# PLANNING AMENDMENT

H06/1126/99.

TWO FACIA SIGNS WITH TROUGH  
LIGHT UNIT.

Amendment: Replacement fascia sign with trough light unit

POSITION OF SIGNS ONLY

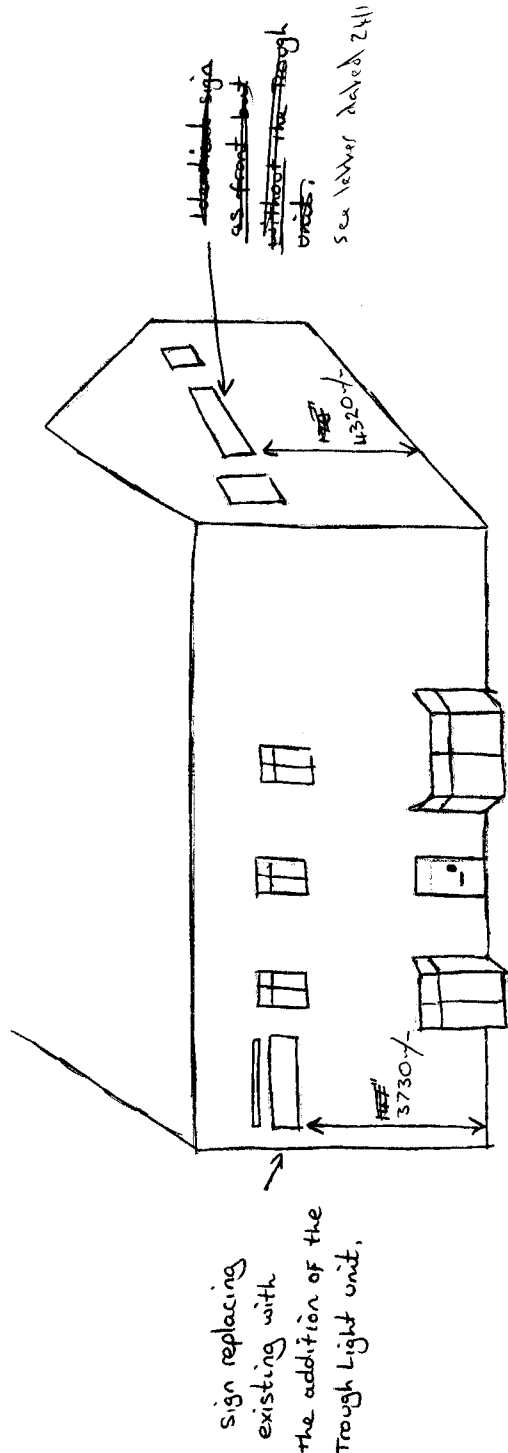
OMIT FACIA SIGN ON  
SIDE ELEVATION.

*REPLACEMENT  
FASCIA SIGN WITH TROUGH LIGHT UNIT.*
